From: Tom Errico <thomas.errico@tylin.com>
To: Jean Fraser <JF@portlandmaine.gov>
CC: David Margolis-Pineo <DMP@portlandmaine.gov>, Katherine Earley <KAS@port...>
Date: 6/16/2015 4:54 PM
Subject: 81 Industrial Way - Preliminary Traffic Comments

SITE PLAN
OF:
LOT 5 INDUSTRIAL WAY
91 INDUSTRIAL WAY
PORTLAND, ME 04103

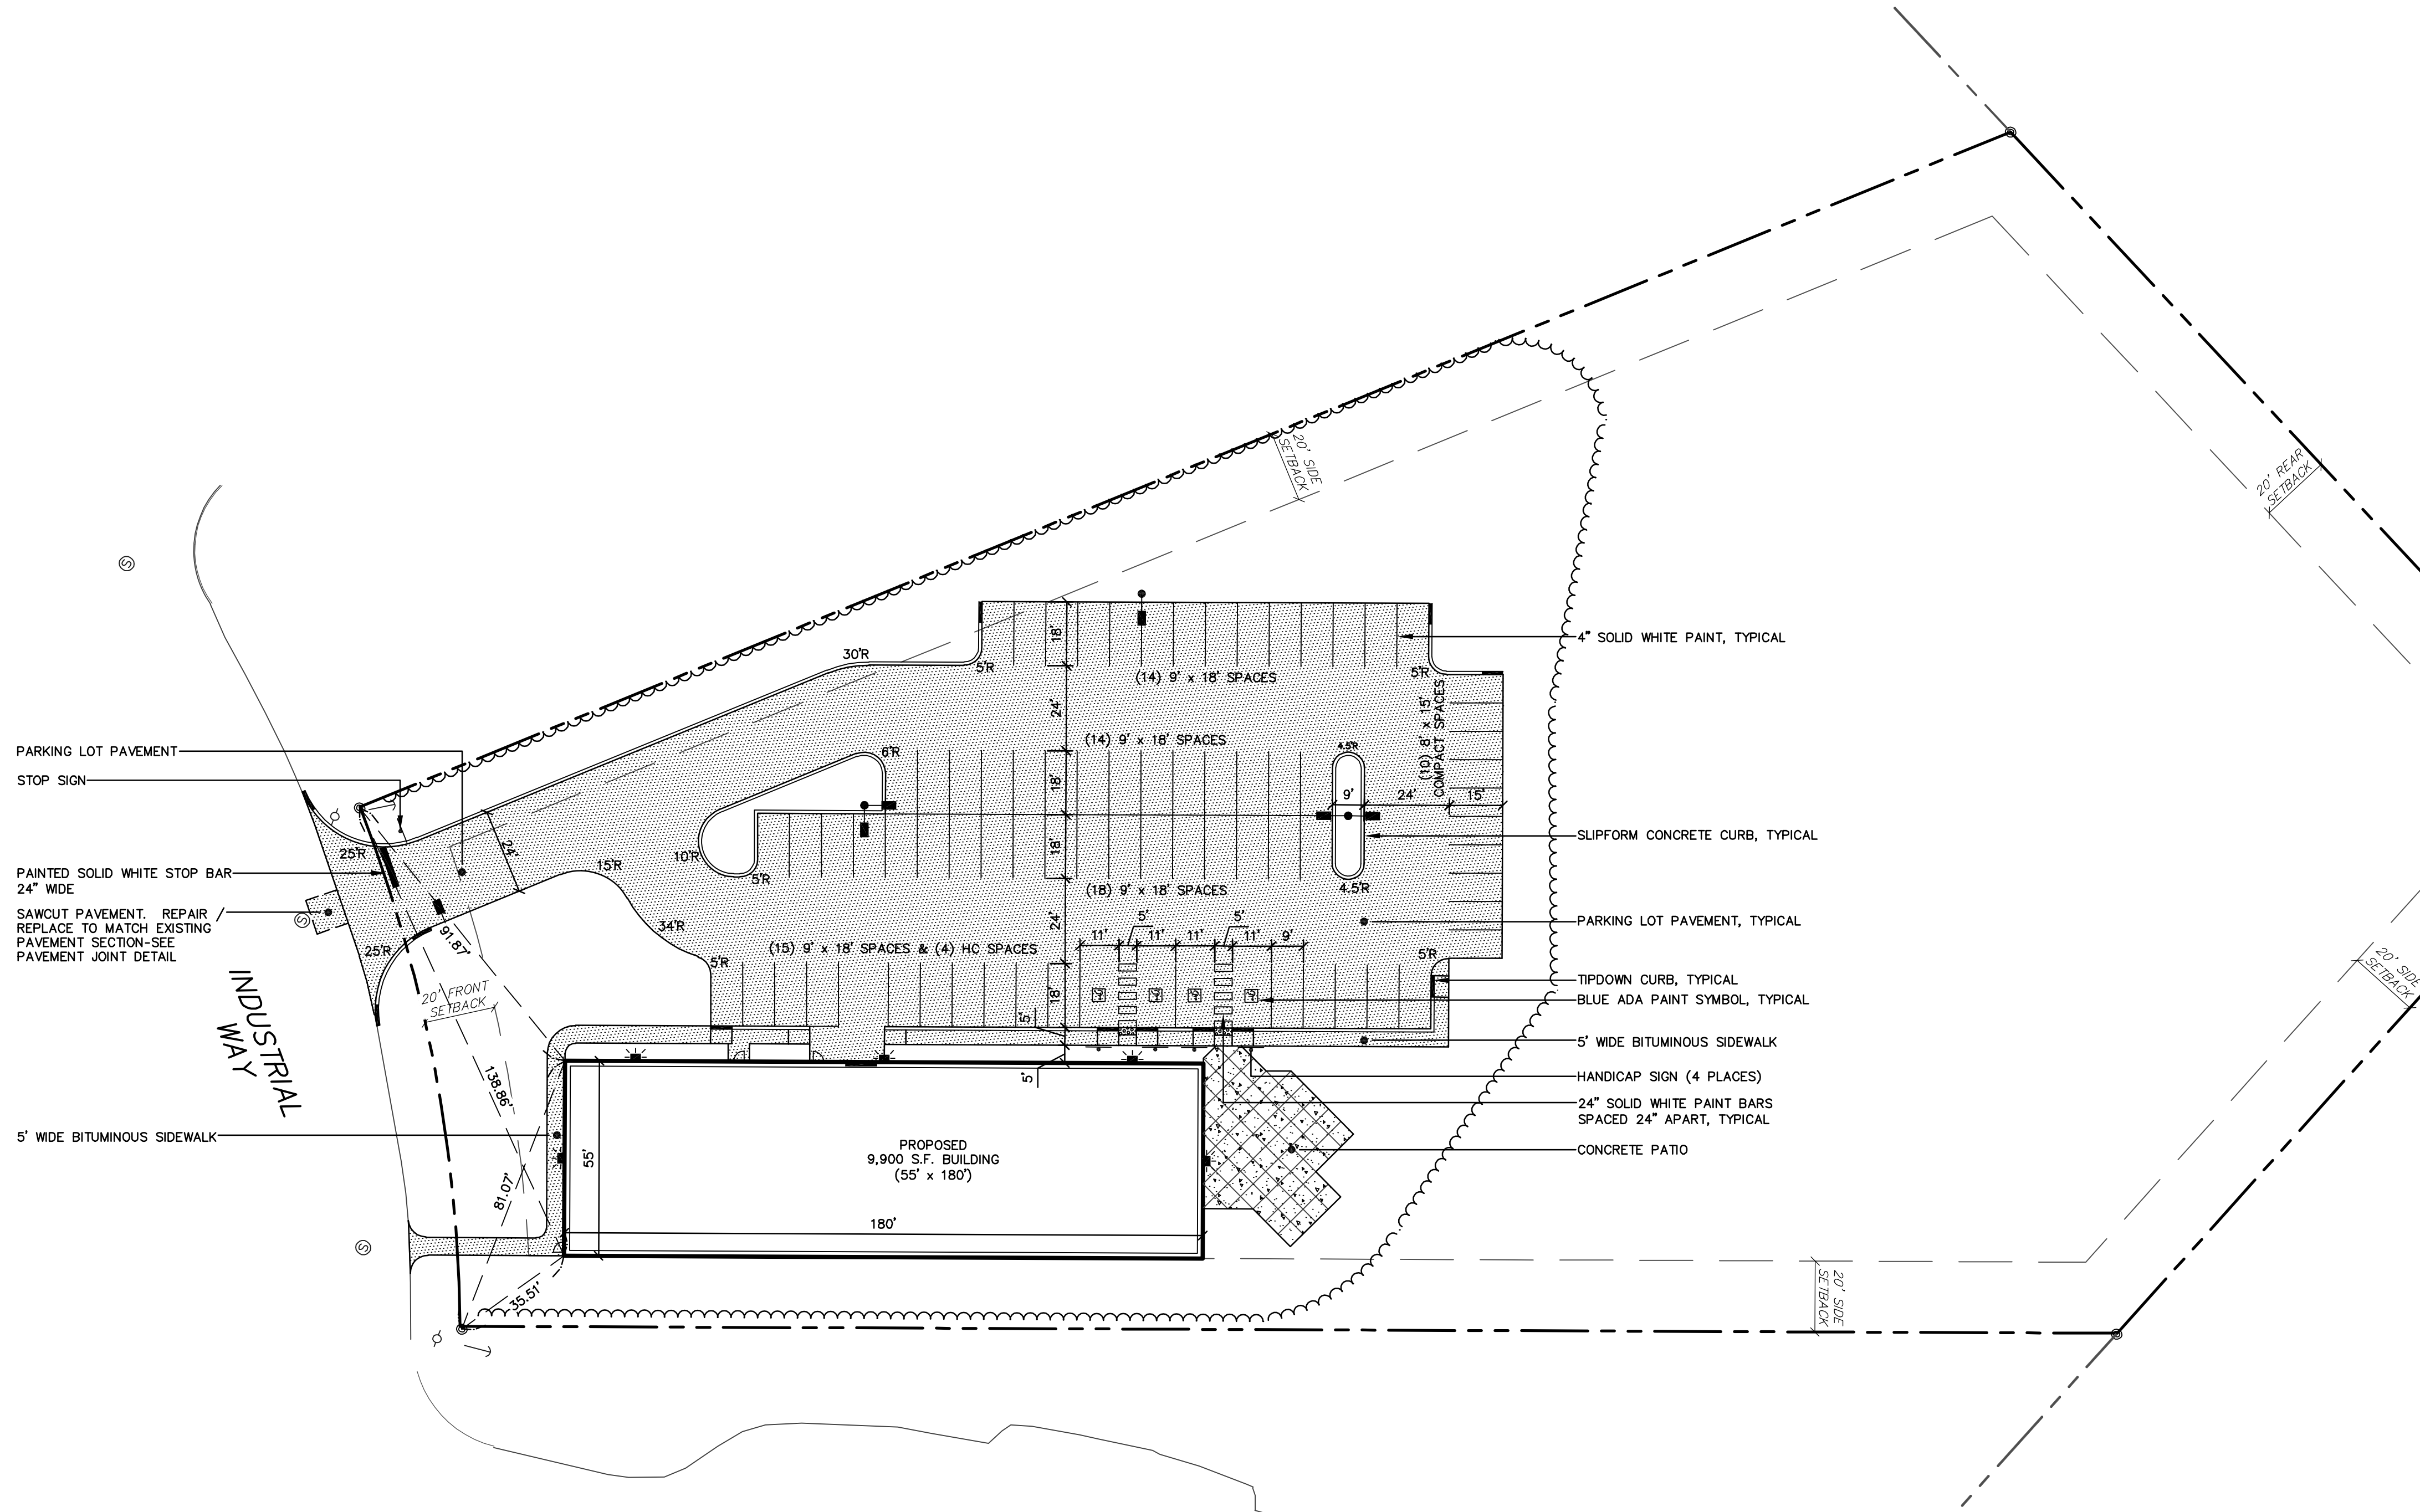
- * The applicant has requested waivers from City requirements for construction of sidewalk and curbing. Given that the City has historically waived these items for other Industrial Way projects, waivers are likely. I need to review these requests in greater detail and with other City staff.

- * The applicant should provide a parking analysis that supports the proposed parking supply.
- * I would expect pedestrian activity between the existing site and the proposed office building and as such the applicant should provide details on routing and facilities to safely accommodate pedestrians.
